Our Ref: BR/25/21/DOC

Town & Country Planning Act 1990 (as amended)
Town and Country Planning (Development Management Procedure) (England) Order 2015
Approval of details reserved by condition imposed under ref BR/257/19/PL relating to Condition No 4 -
balcony railings (height, finish, manufacturer/model name)
The Royal Hotel The Esplanade Bognor Regis PO21 1SZ

Arun District Council have decided to **APPROVE details reserved by this condition**

REVISION	REVISION DATE	REVISION DESCRIPTION
P02	09.06.2020	FOR APPROVAL

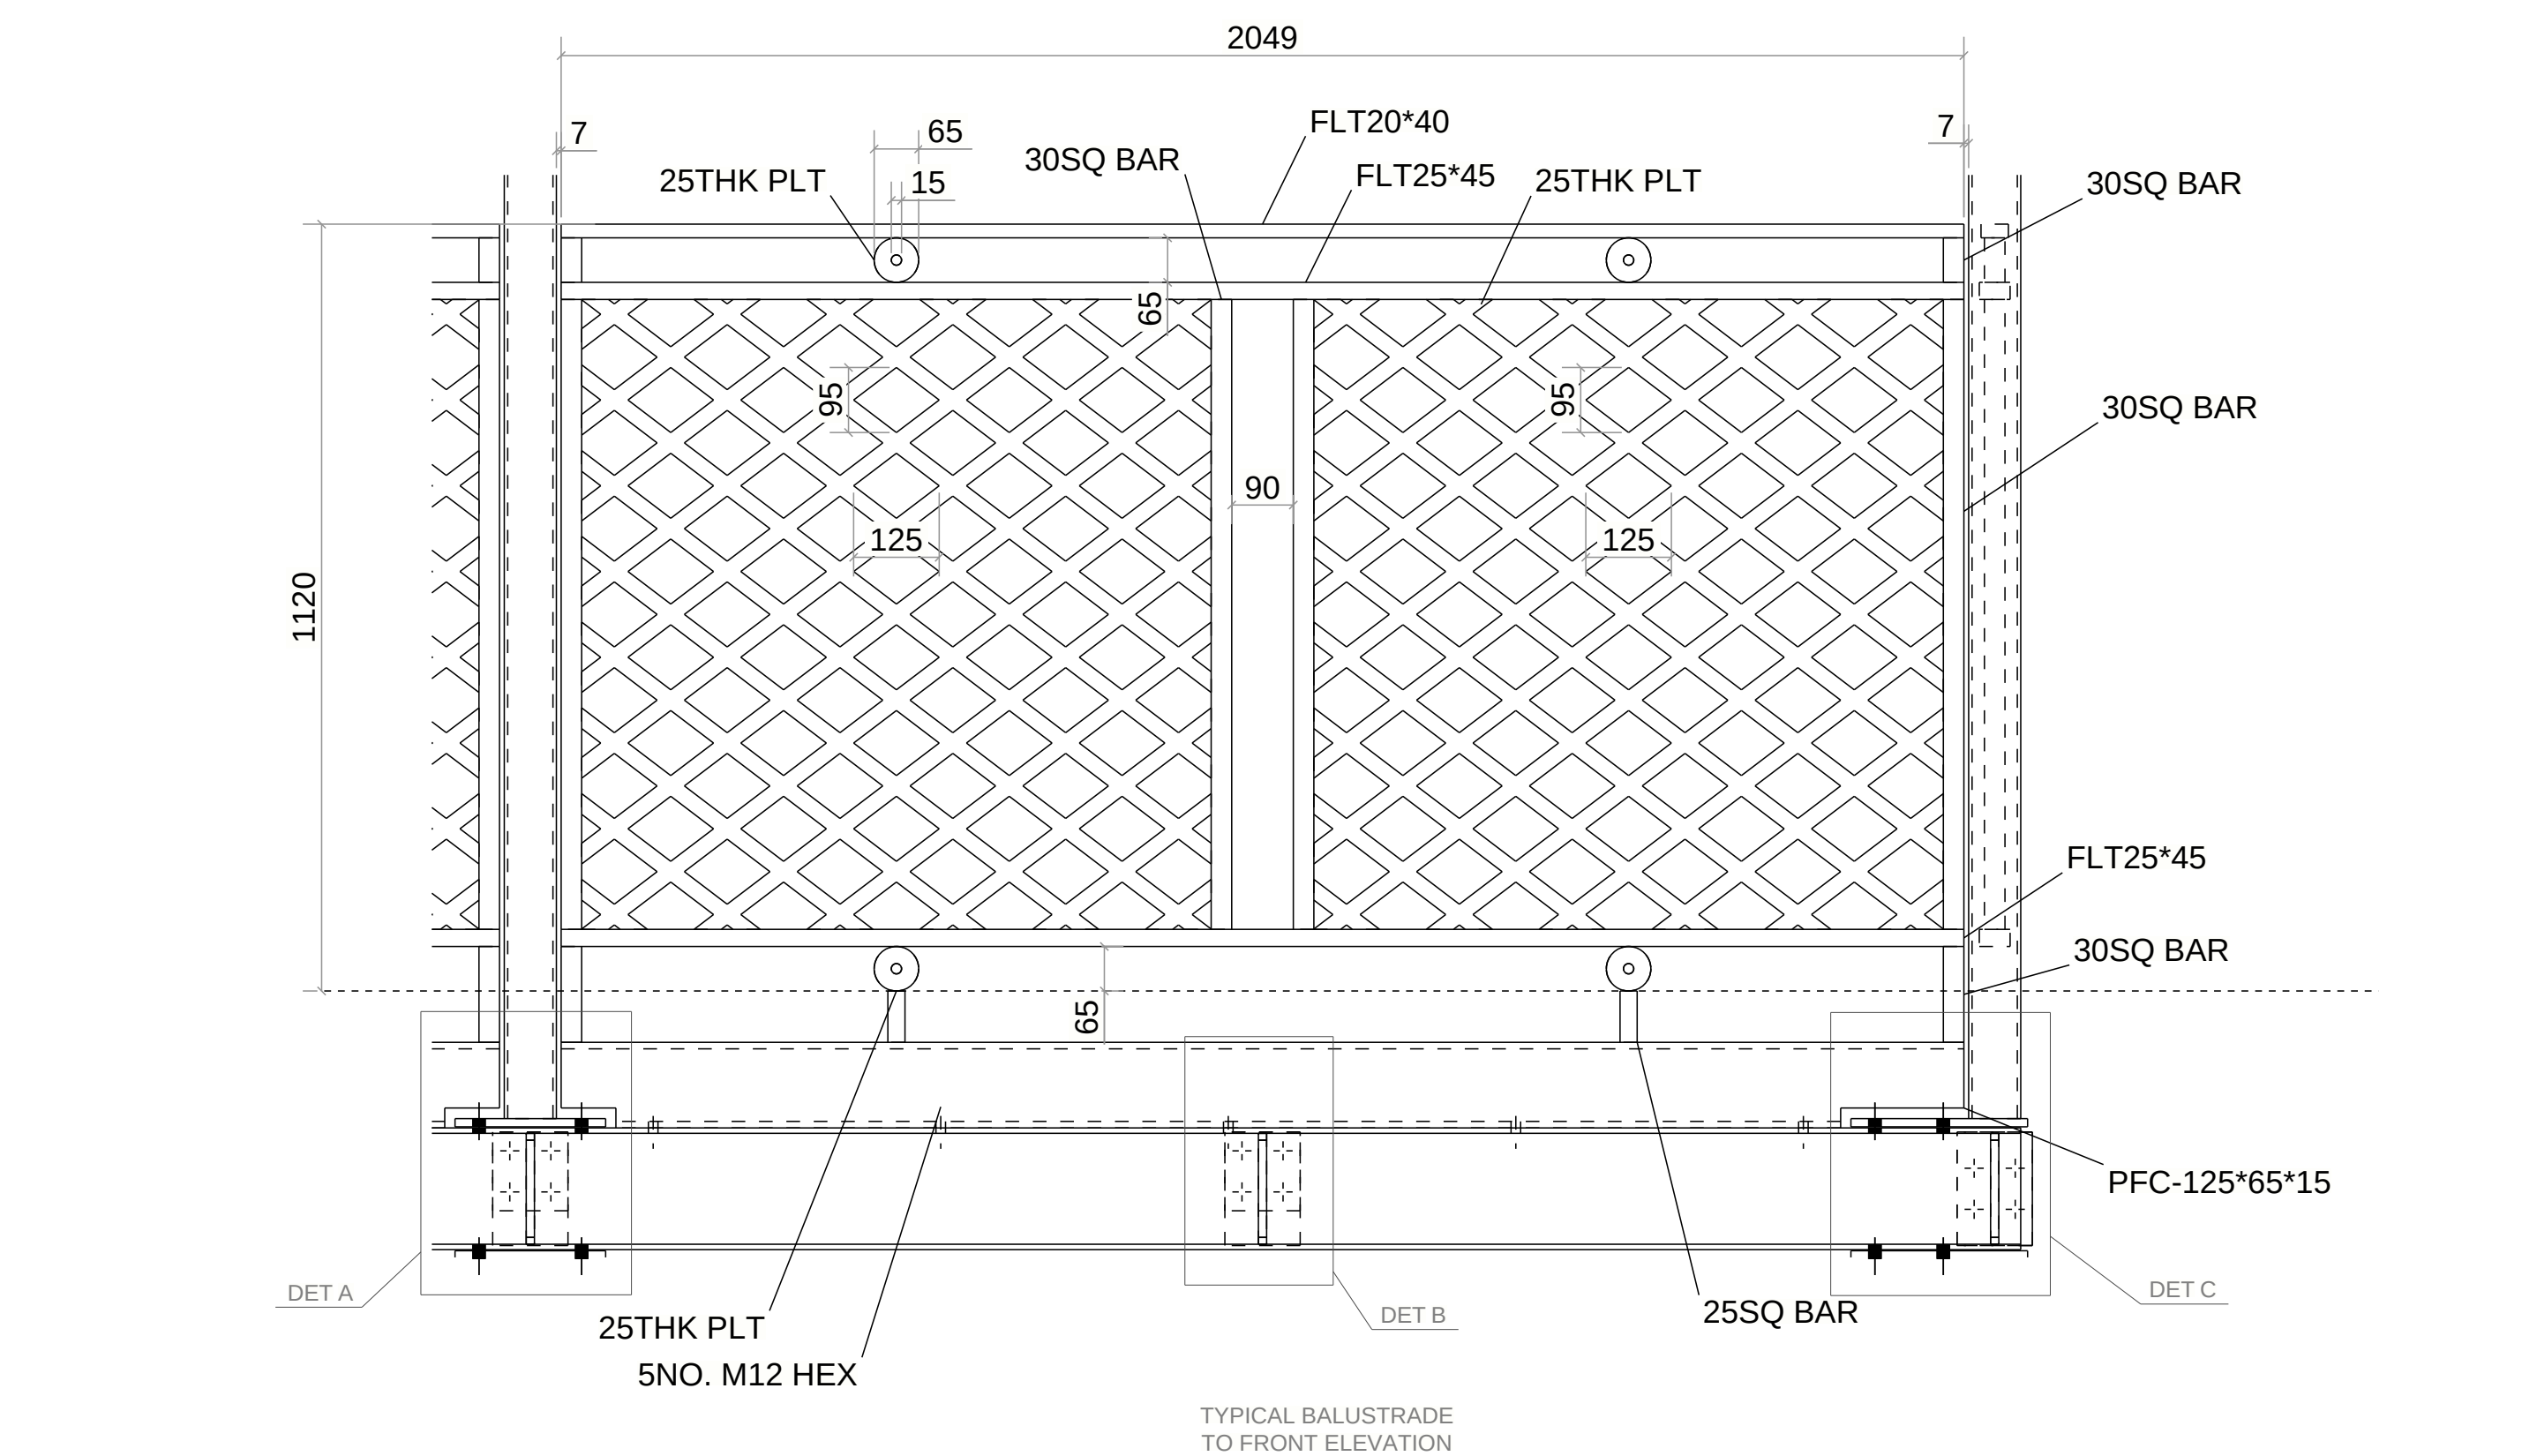
Type 4 - New Metalwork, proposed height 1120mm, black painted, Bespoke railing produced by Alpine Group, drawing "S4068-GA-001" and "S4068-GA- 002".

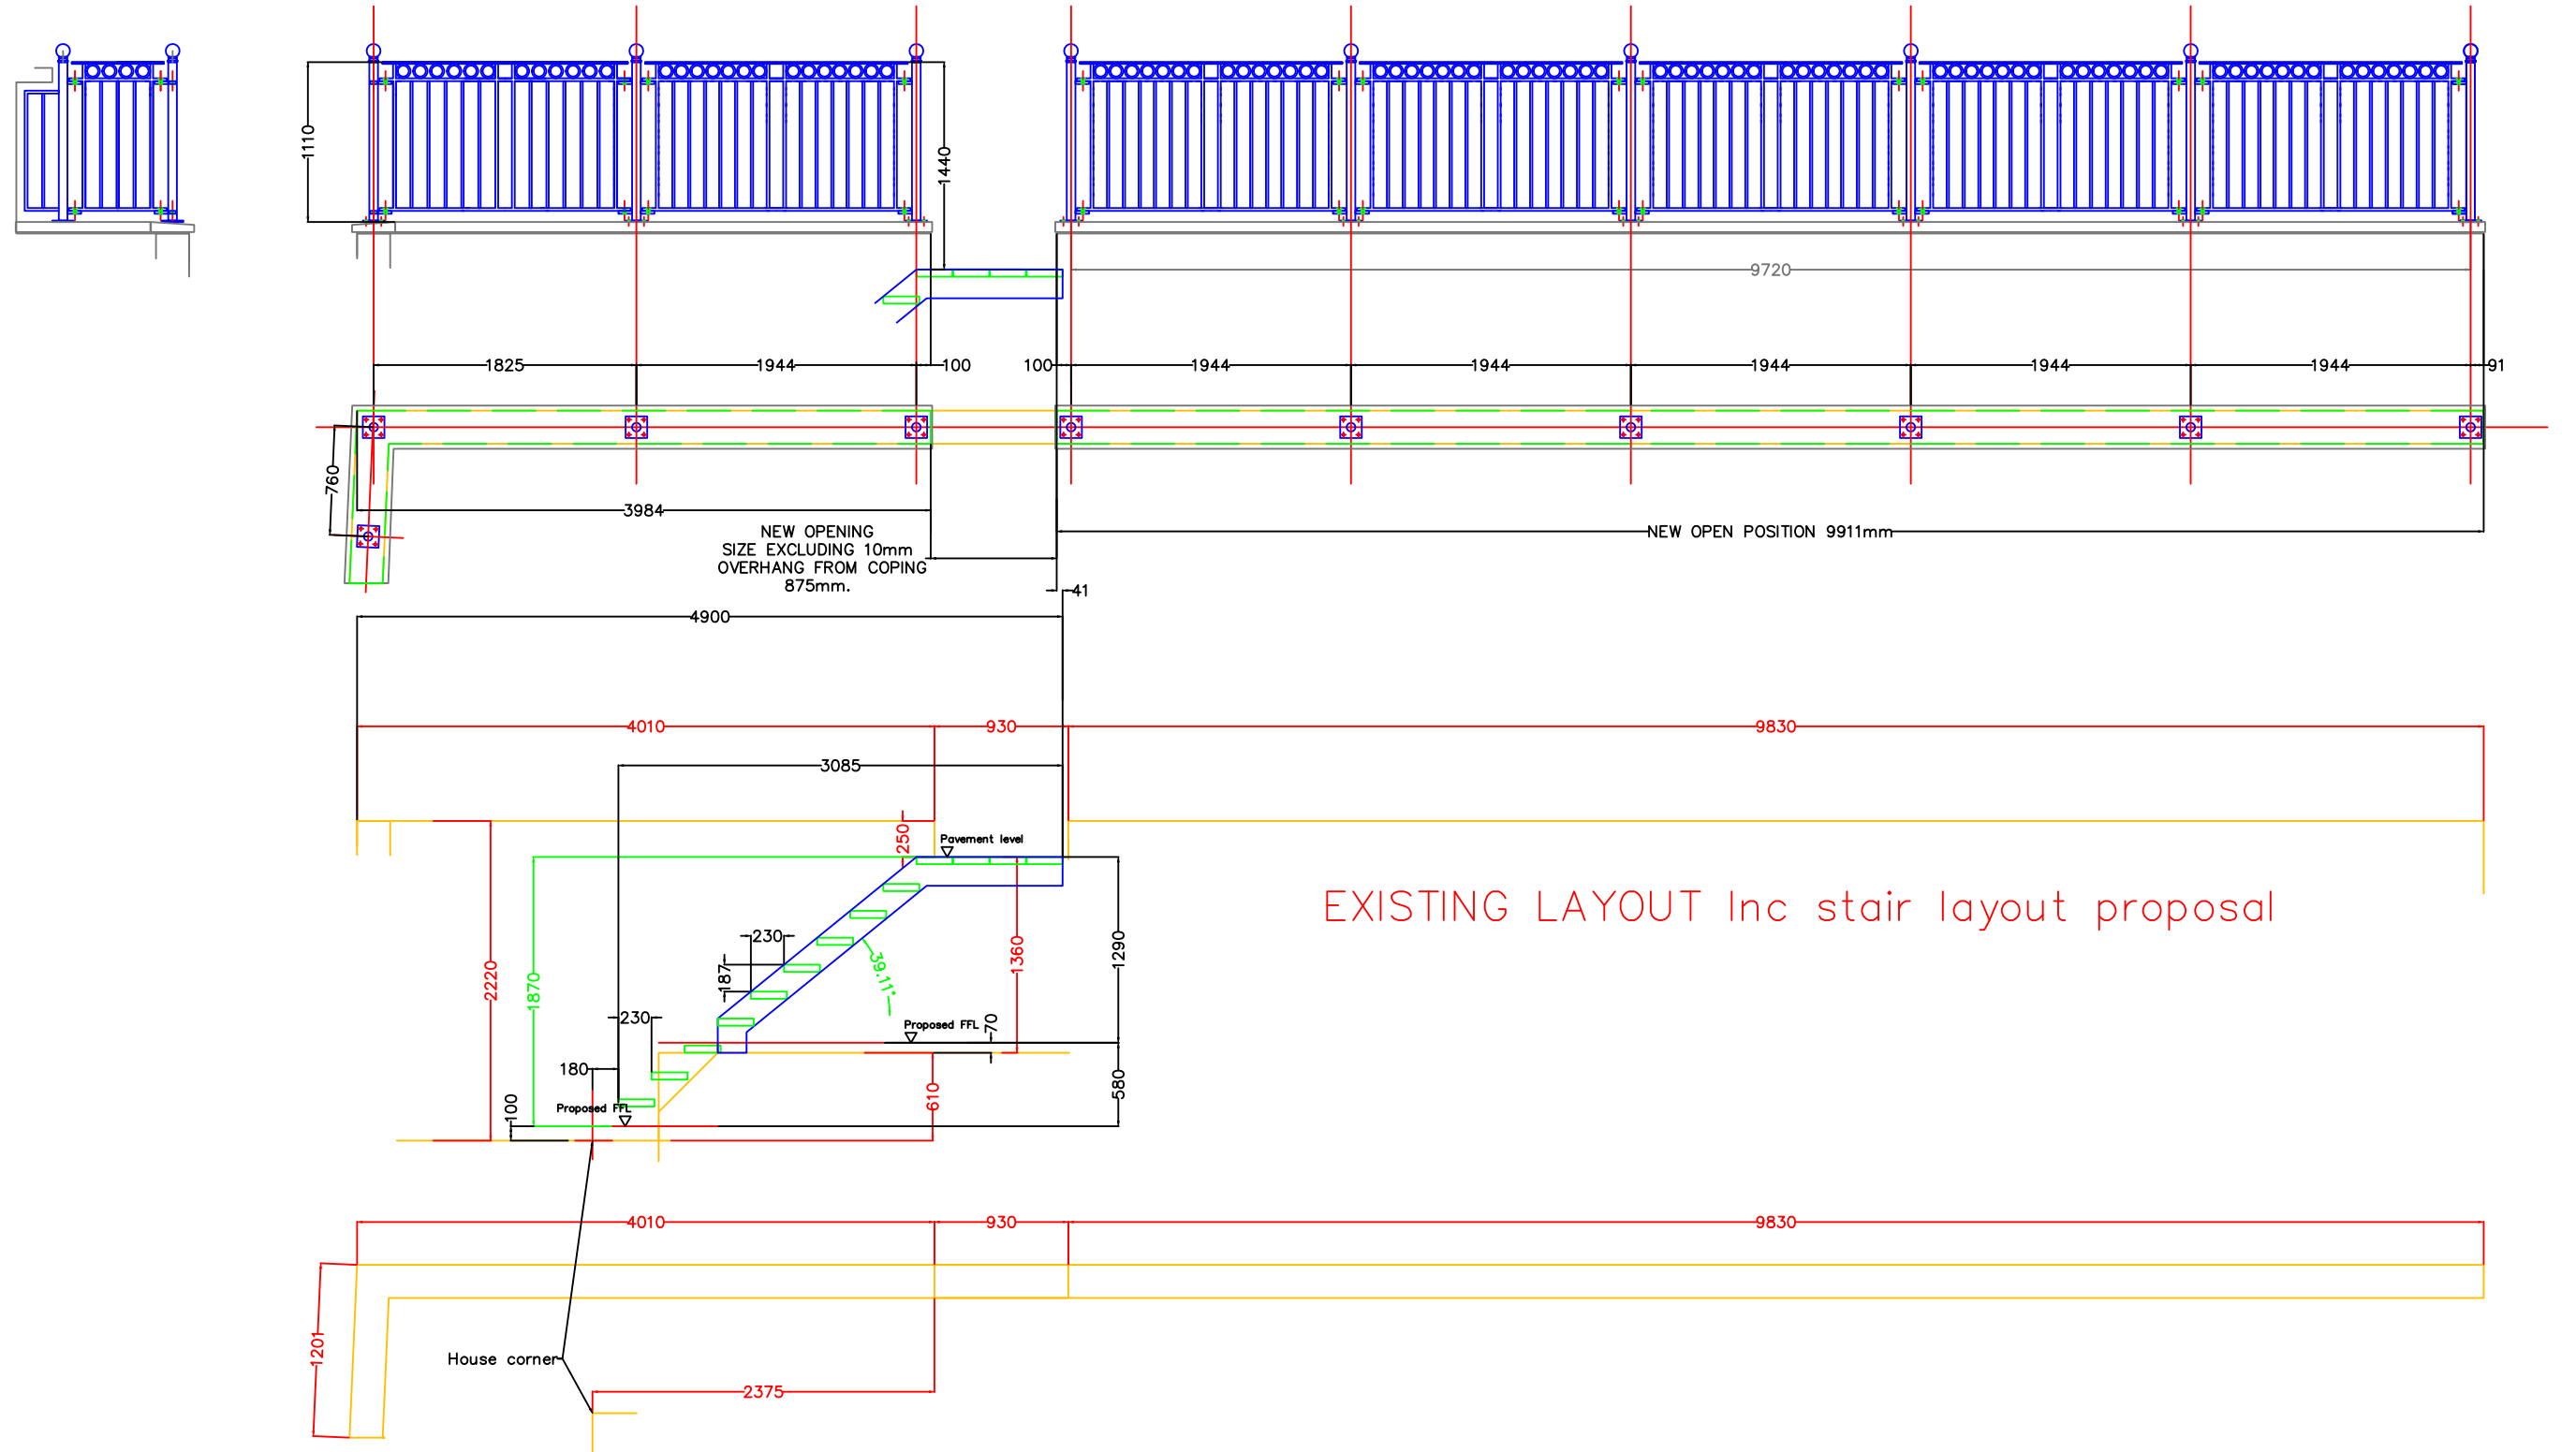
Type 5 - New Metalwork, proposed height 1100mm, Bespoke railing produced by OBE Fabrications, drawing "7595 - Front Railing Layout"
